From: Stephen Garrard [REDACTED]
Sent: 30 July 2020 10:12
To: Anita Gardner <Anita.Gardner@arun.gov.uk>
Subject: RE: AB/63/20/DOC Canada Road, Arundel

Local Highways Comments pertaining to Condition 4 (site layout).

Subject: AB/63/20/DOC Canada Road, Arundel

- Indicates Site Cabin - Oasis Unit Location
- Indicates Proposed Materials offloading Area to Storage Area/s.
- Indicates Proposed Materials Storage Area
- Indicates Proposed Contractor Parking Provision (on-street)

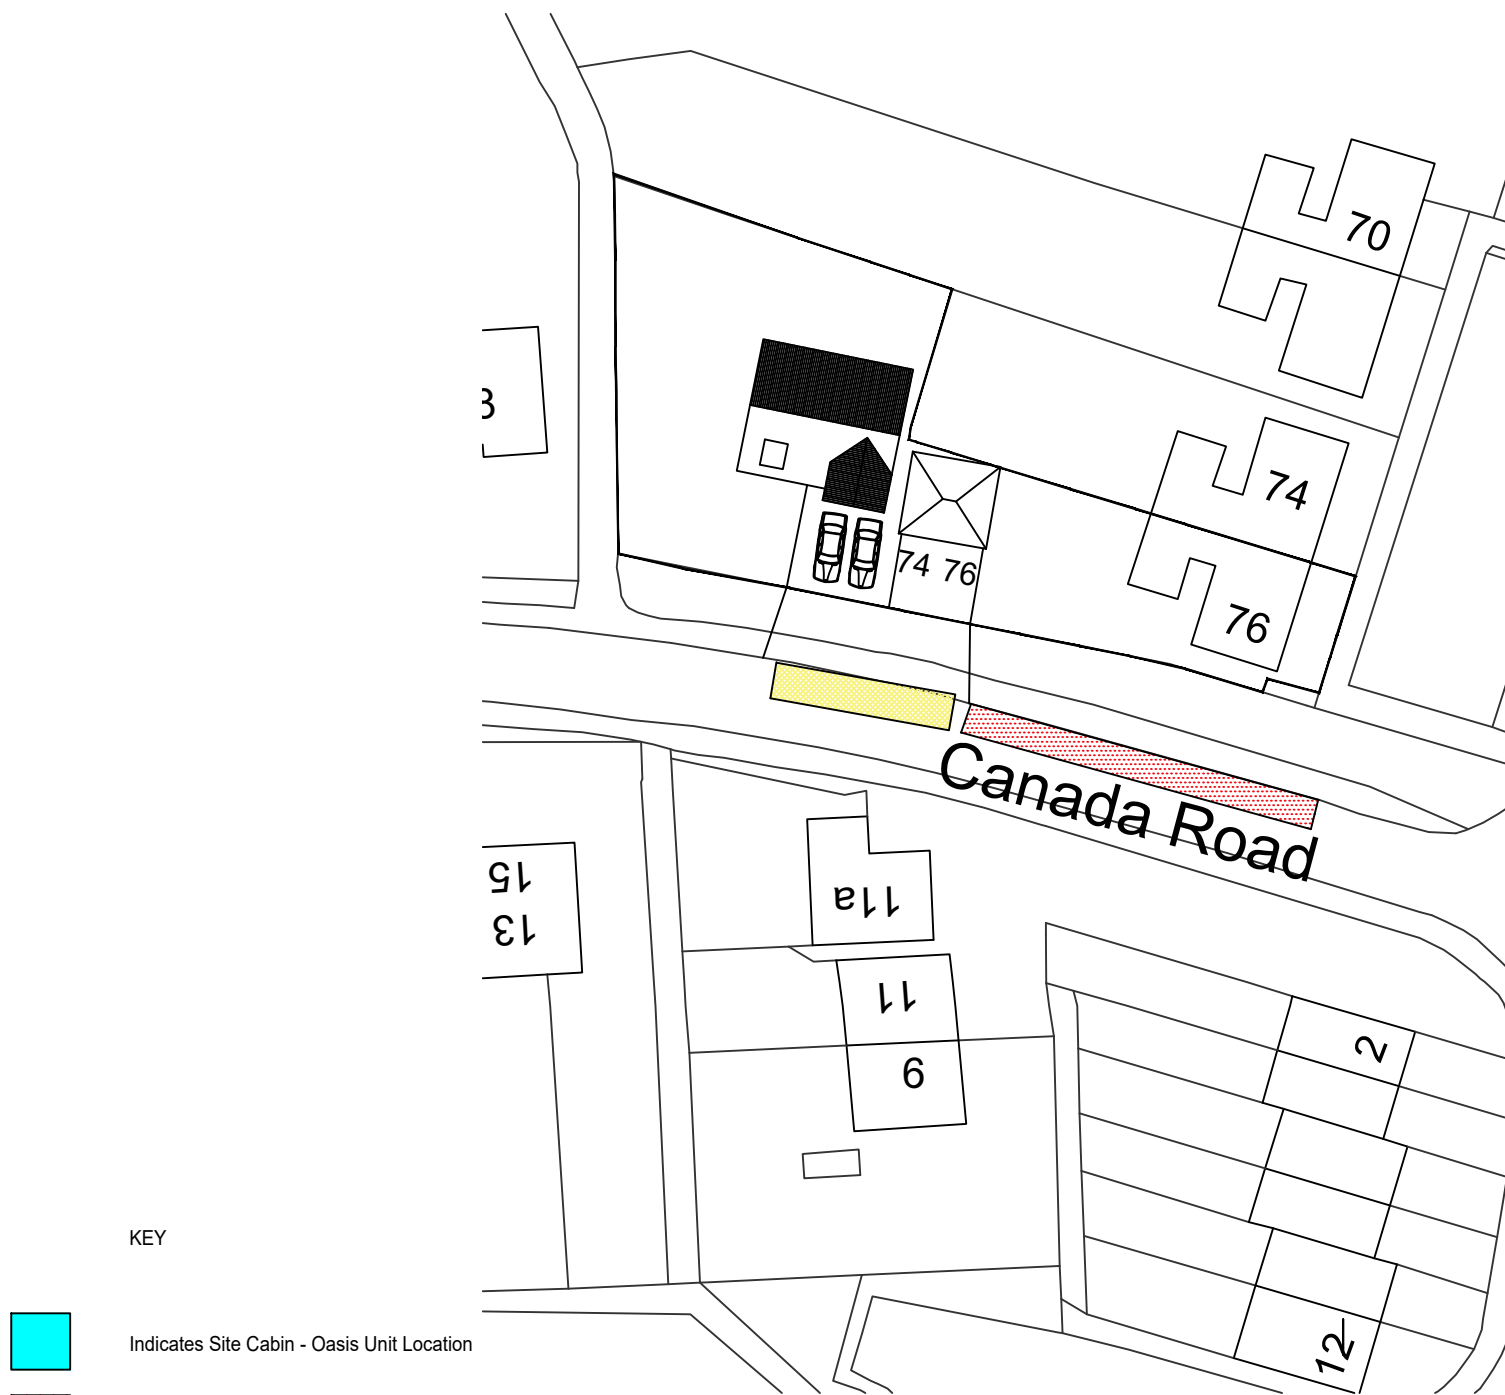
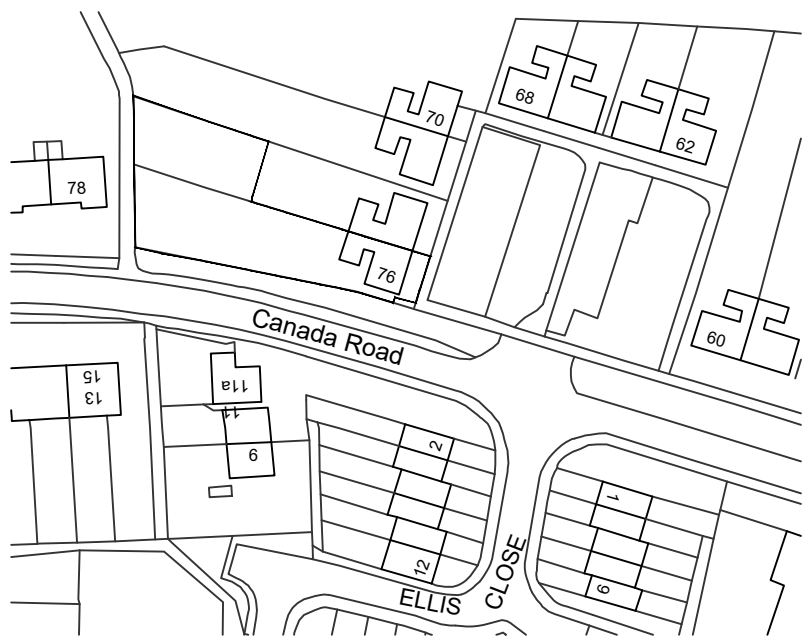
The LHA does not accept storage of materials within the publicly maintainable highway. The LHA asks the applicant to amend the plans.

The LHA does not accept parking provisions for workers within the highway, please amend.
